Your Ref: OWPC15424
Our Ref: M/71/17/HH 21-07-2017
Please ask for:
Mr D Easton

Two storey side extension with 2 No. dormers to front elevation.
Little Thatch 93 Middleton Road Middleton on Sea

Thank you for your internet representation made on 31st August 2017 which has been recorded as '**an objection**' with the comments as follows:

SITE PLAN

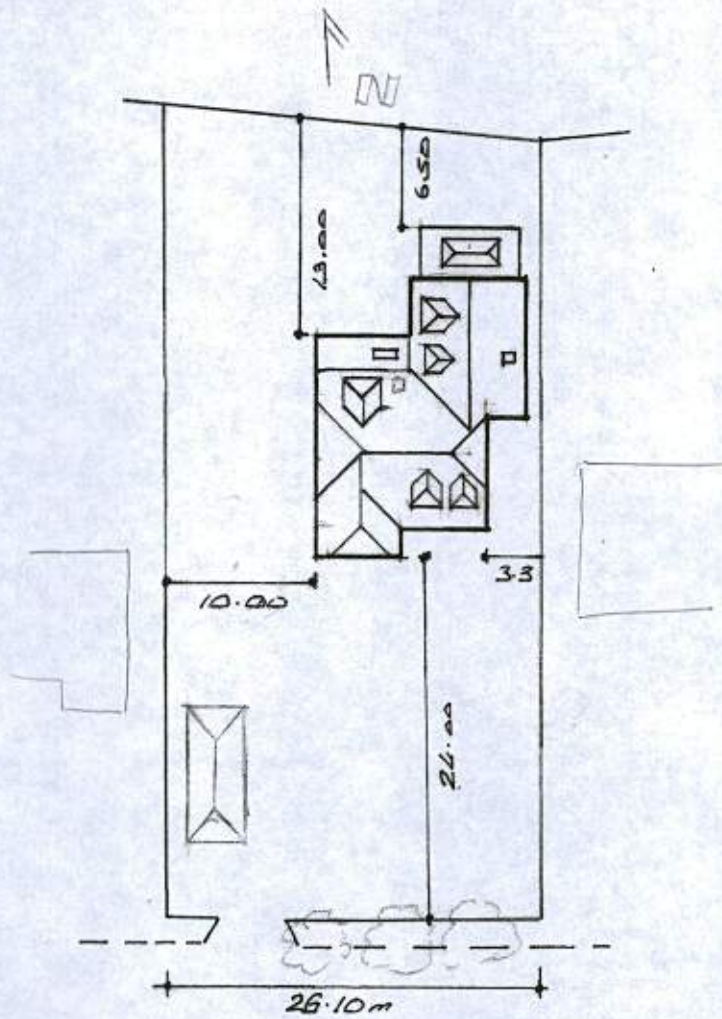
The house, annex and conservatory already extends 100% along the usable length of our garden. The additional height of the house and annex with the close proximity to the boundary will make this development overbearing and unneighbourly.

The current annex is extremely close to the boundary. Increasing the height so dramatically will only increase the feeling of being loomed over by a large building.
